Response to Planning Application

From: Arun District Council Leisure & Greenspace

Application ref: BE/99/20/EIS

Description: Scoping opinion request relating to 2500 new homes, up to 3.52ha of employment land, a 3 Form Entry primary school, 2 local centres and associated infrastructure across approximately 141 ha of land.

7.3.5 Illustrative Green-Blue Infrastructure Character Diagram

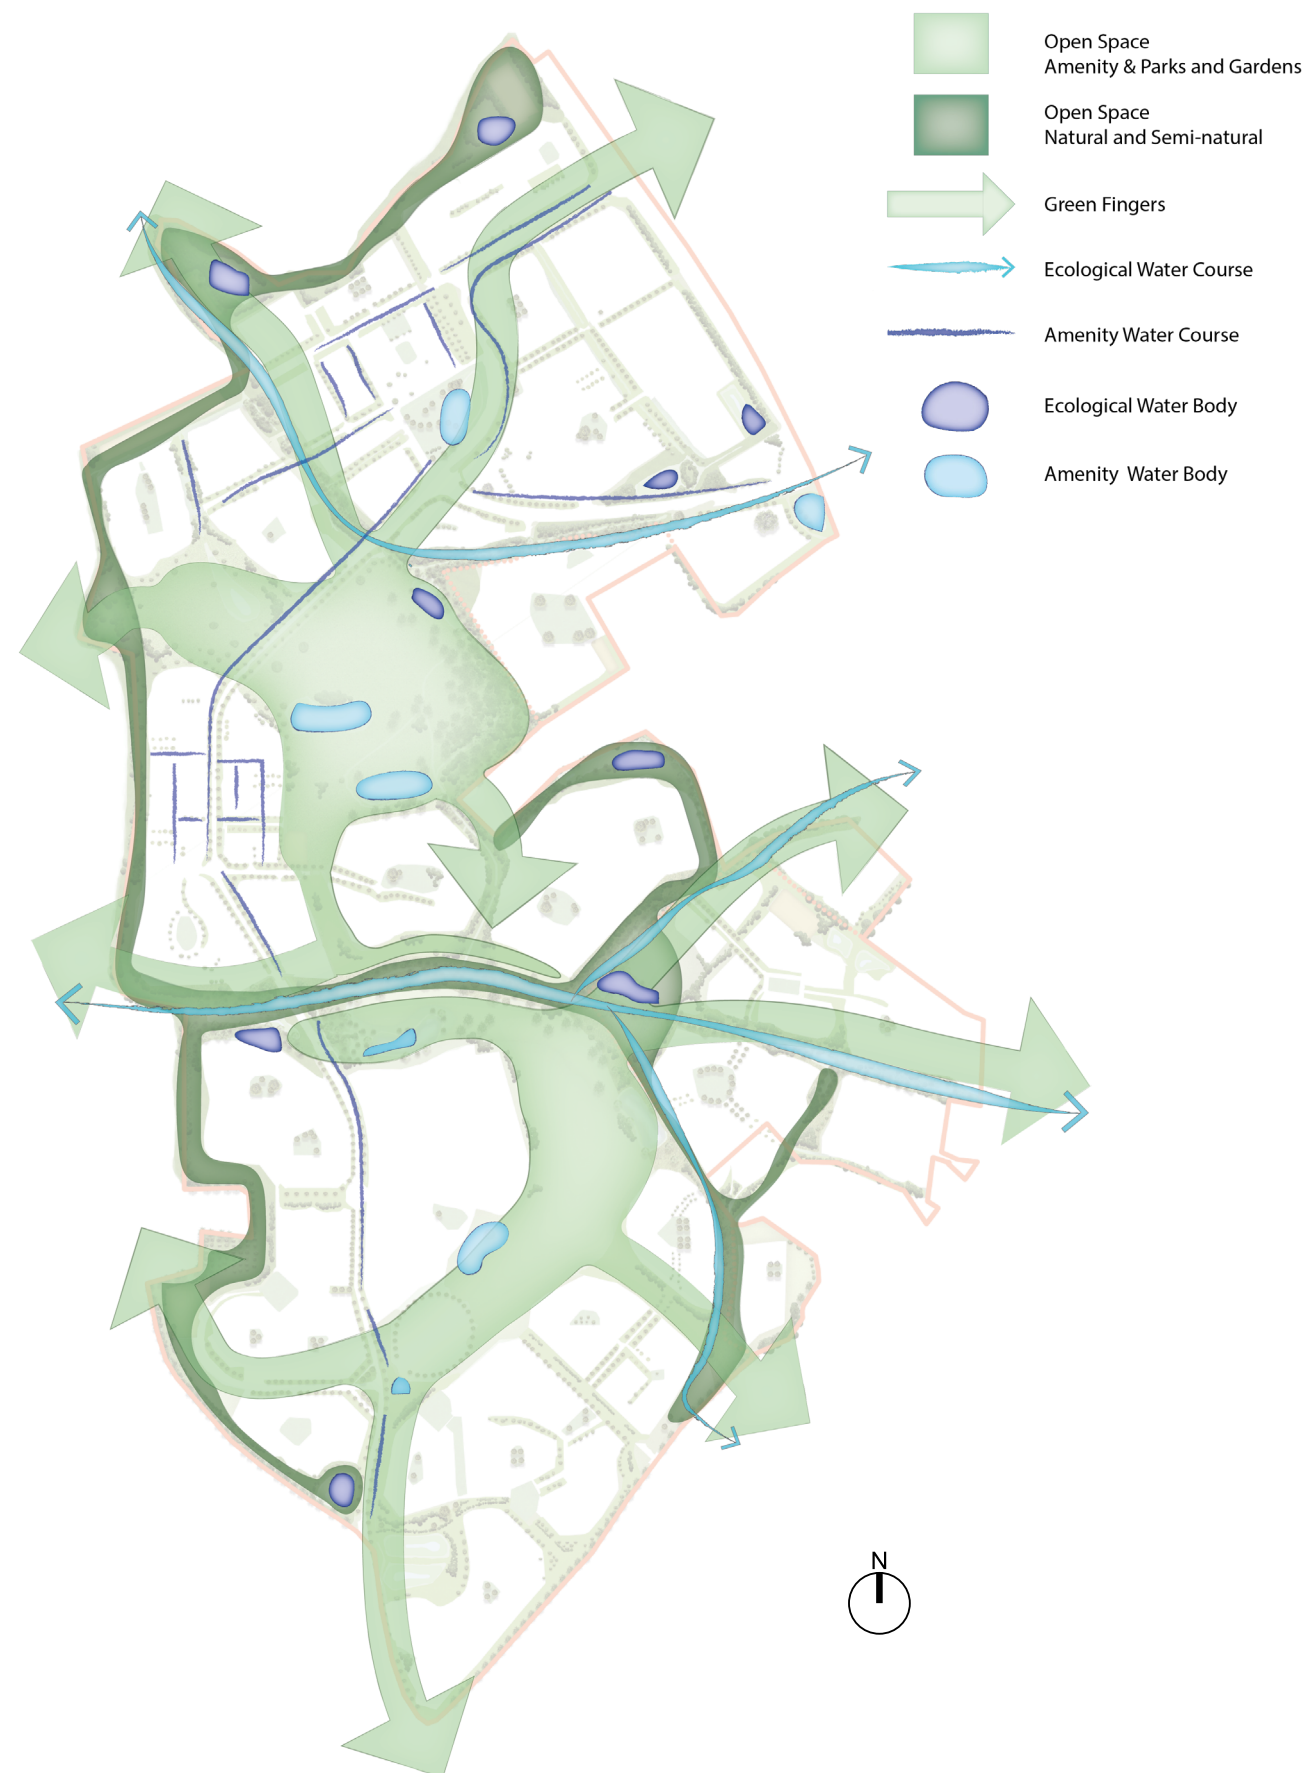
It is understood that water table monitoring is ongoing and therefore the full extent of the impact of the SuDS on the open space is not concluded. There are currently inconsistencies in the location of SuDS shown on plans which have an impact on the layout of open space and sports provision. The permanent pond/lake associated with the retail area being one example.
